## CONSULTATION UNDER TOWN AND COUNTRY PLANNING ACT 1990

<b>Application Number</b>	<b>PL/2023/01354/PPFL</b>
<b>Address</b>	<b>53 Kingfisher Drive Smiths Wood Solihull B36 0RP</b>
<b>Proposal</b>	<b>Demolish the existing single storey vacant local shop building on the corner of Kingfisher Drive and Eagle Grove and construct 2 No. two story affordable energy efficient residential dwellings.</b>
<b>Case Officer</b>	<b>Rebecca Hadley</b>

<b>Date comments sent</b>	<b>19/07/23</b>
<b>Name of consultee department</b>	<b>Highways</b>
<b>Consultation response author</b>	<b>Gurdip Nagra</b>

Proposed Floor Plans and Elevations

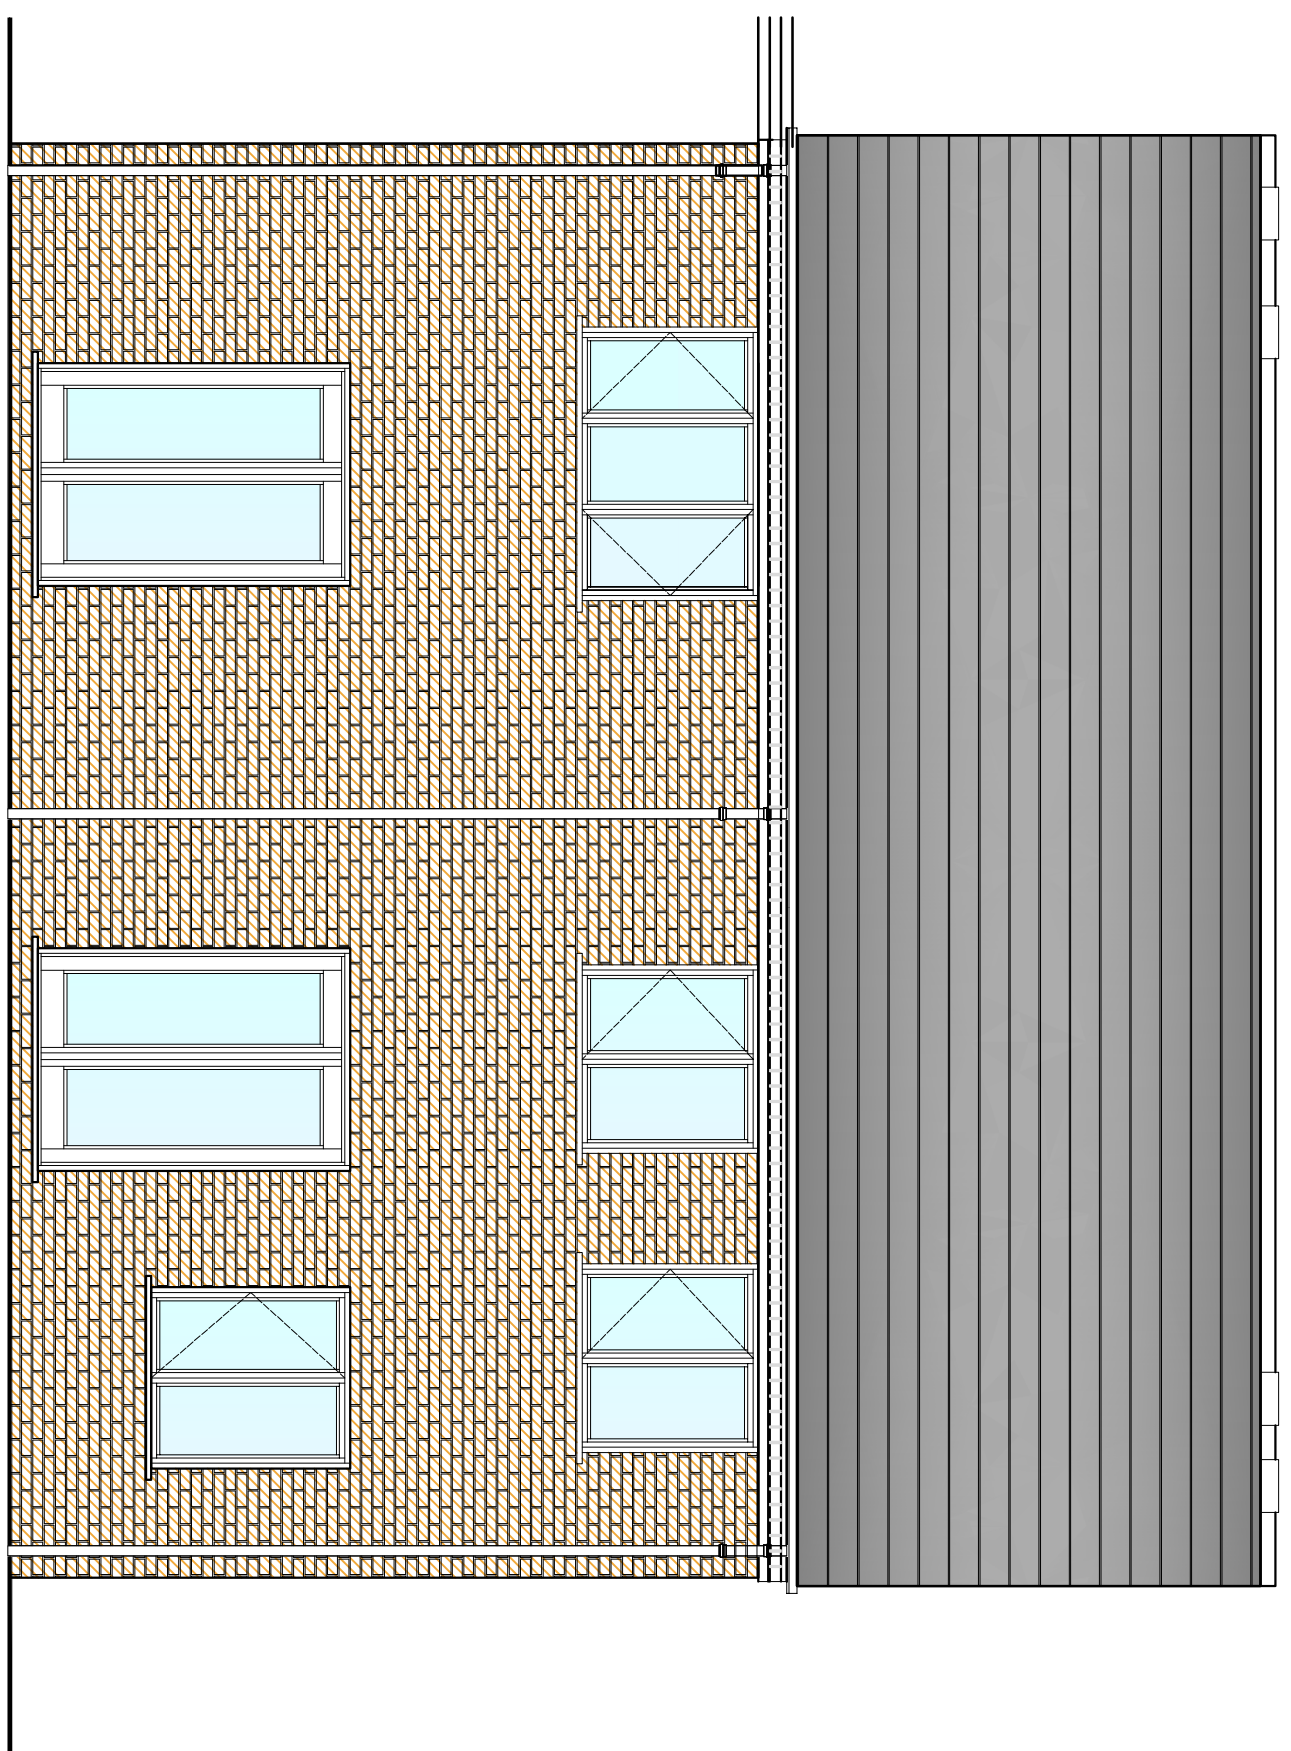
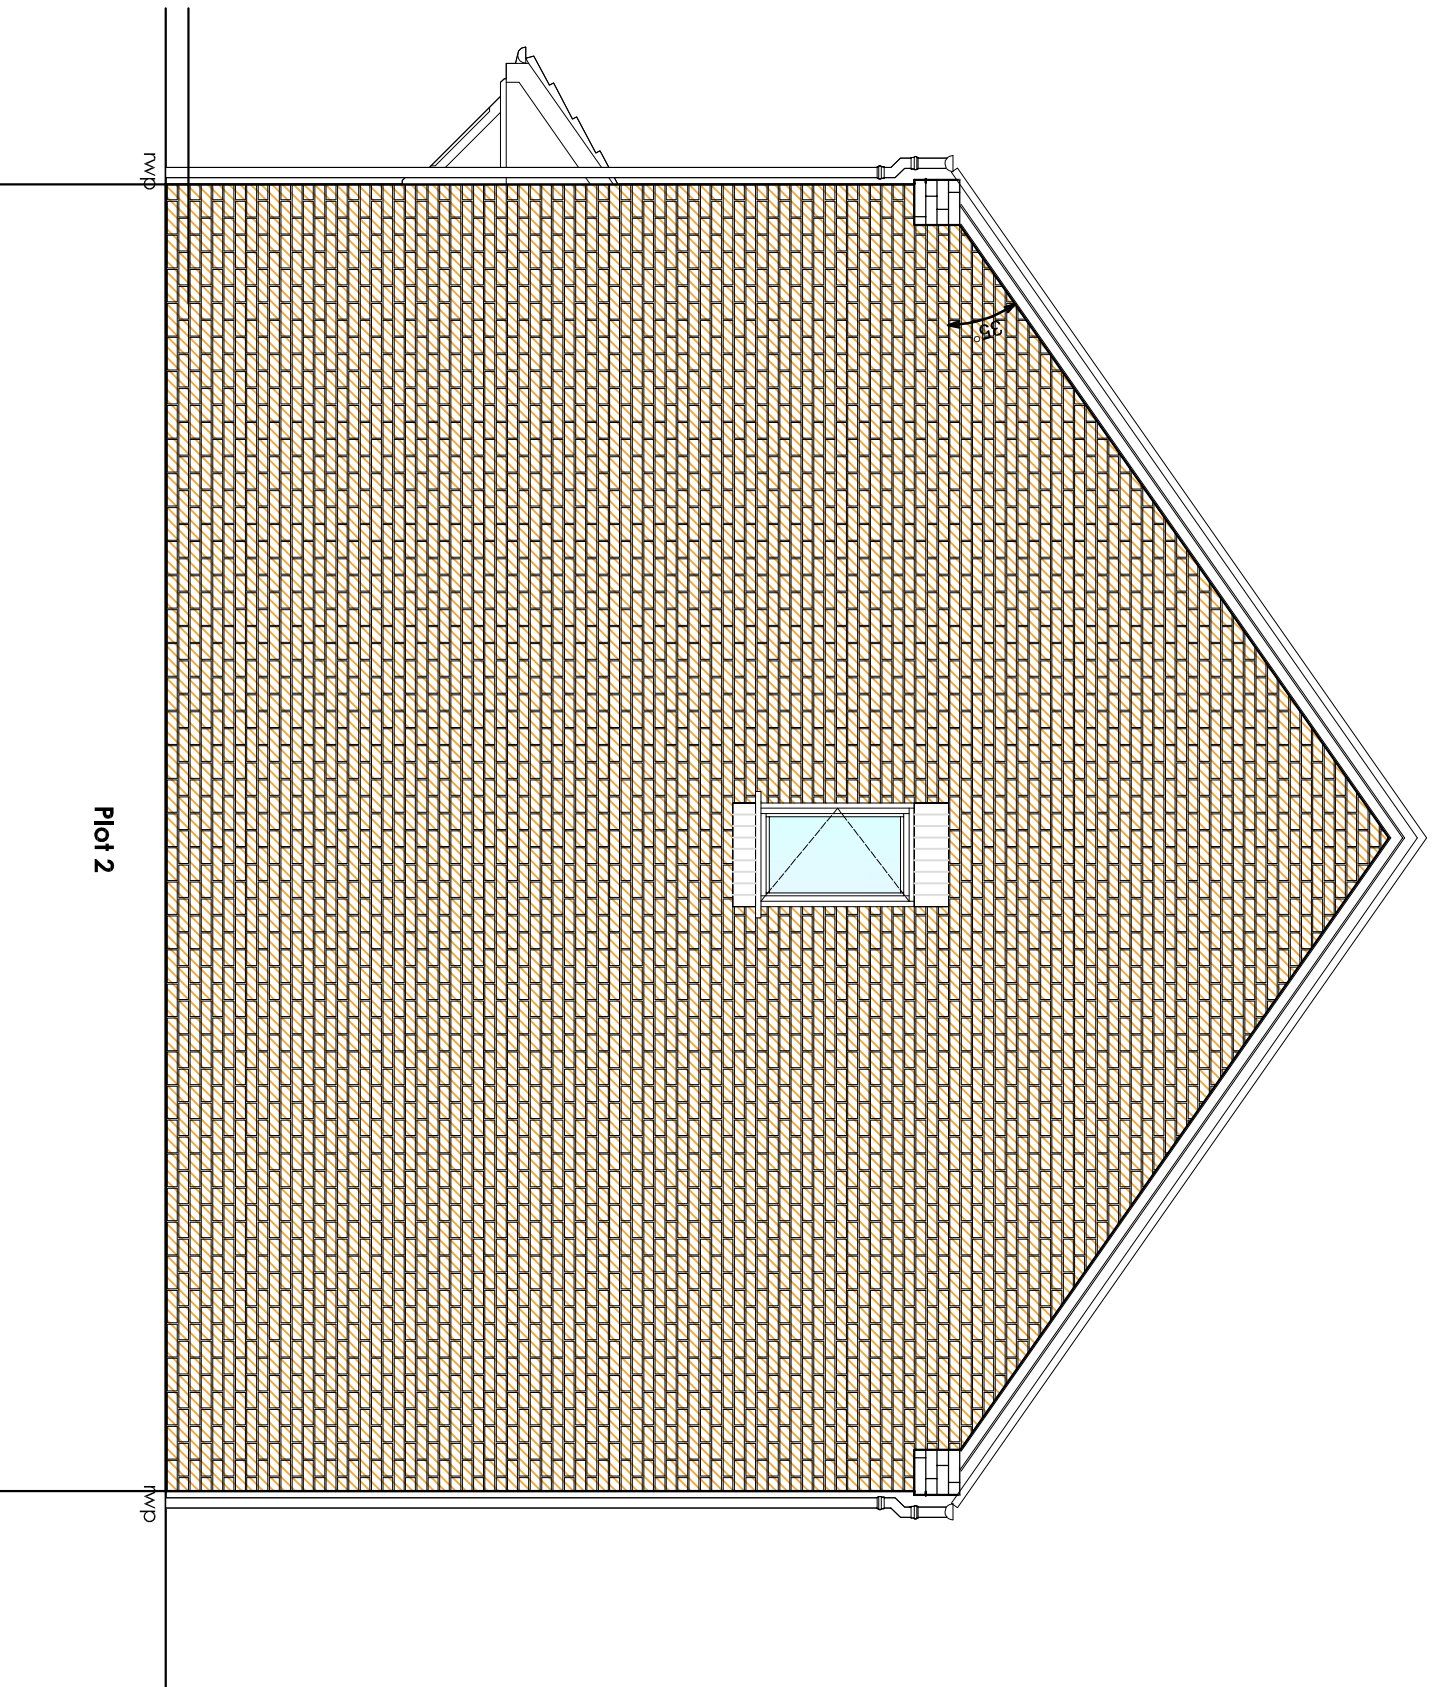
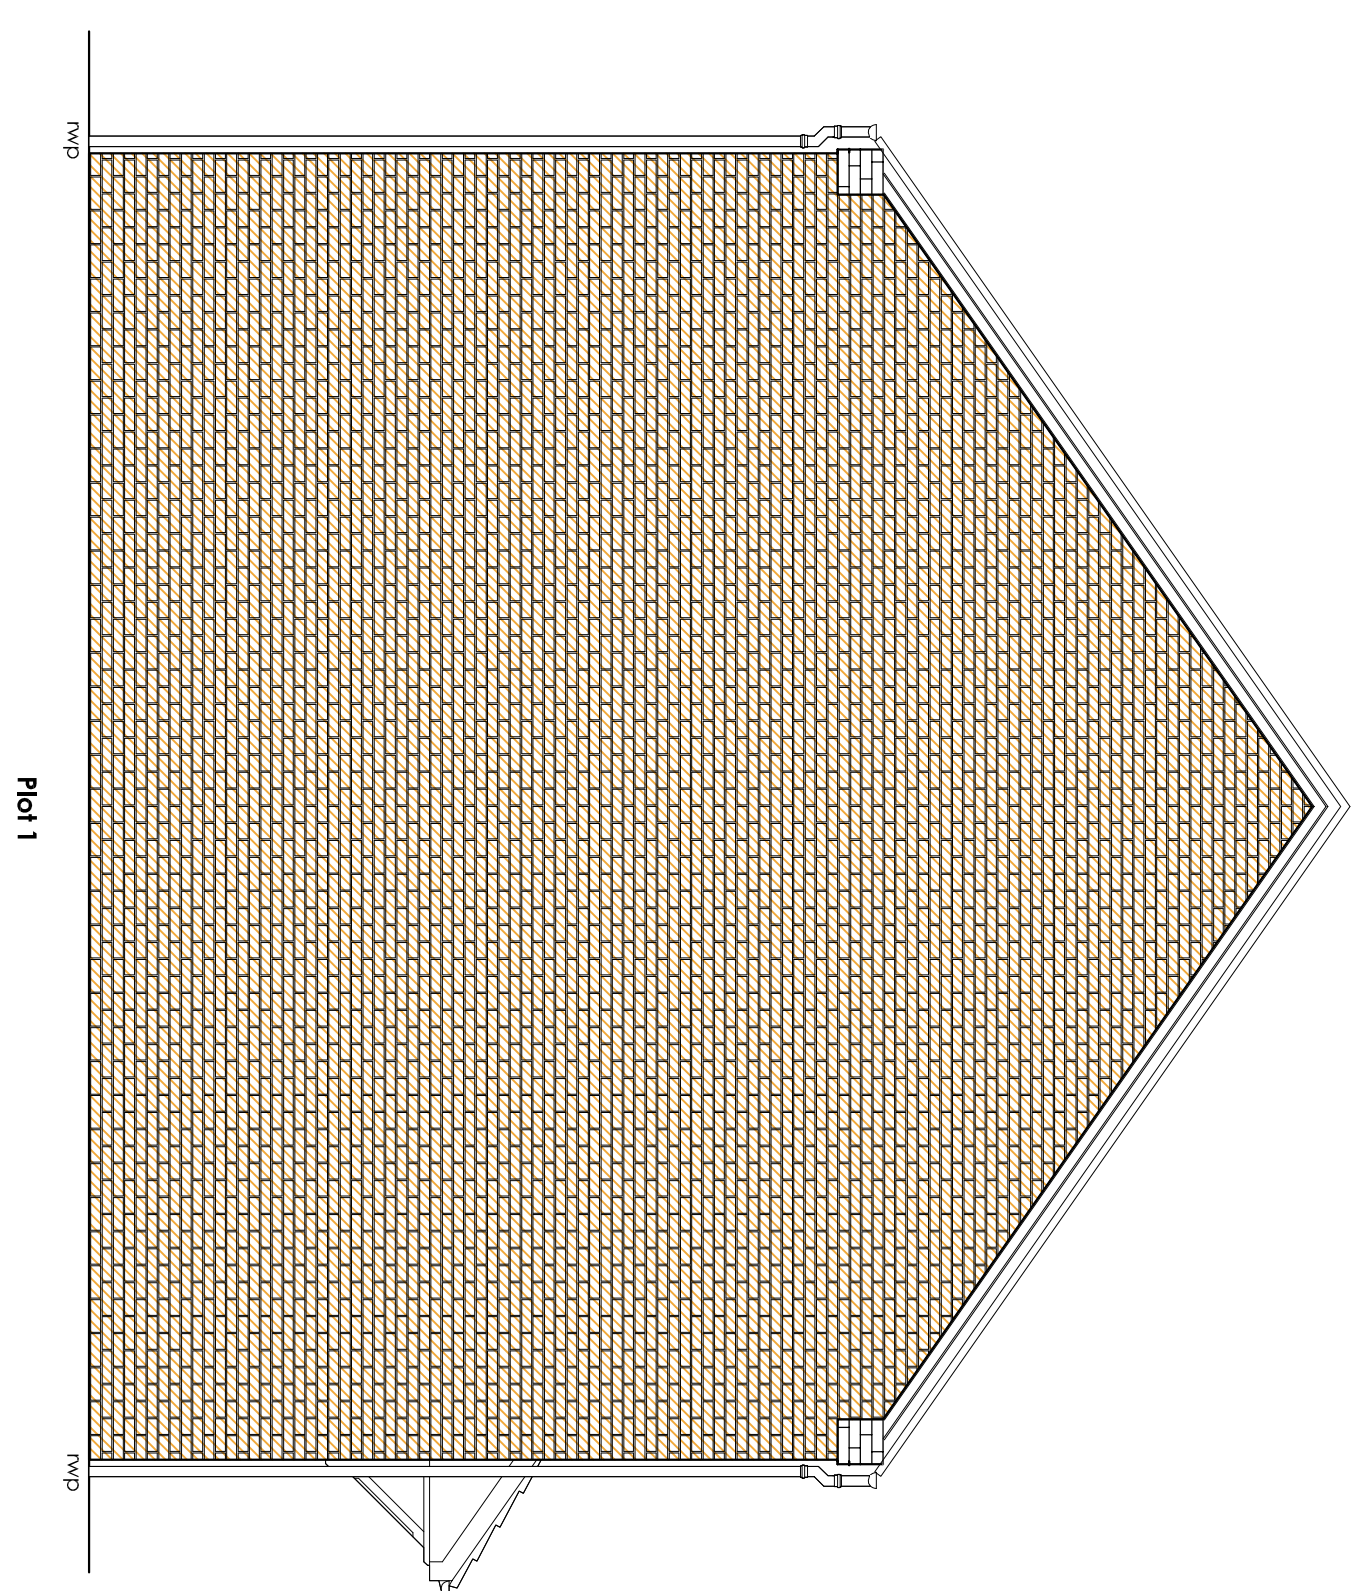
The development proposals include the demolition of the existing commercial building on the corner of Kingfisher Drive and Eagle Grove and construction of 2 No. two story residential dwellings. The development proposals will not increase the available parking on site and would remain at 2 spaces. The Highway Authority has concerns that insufficient parking shall be provided for the proposed dwellings, which would result in vehicles parking on-street and obstructing the public highway. The available on street parking to serve this development in this locality is limited and the site is adjacent to a primary school, therefore a parking survey is not being sought.

Insufficient off-street parking has been proposed for the proposed dwellings. It is therefore considered that the development proposals fail to accord with Policies P8 and P15 of the Solihull Local Plan 2013.
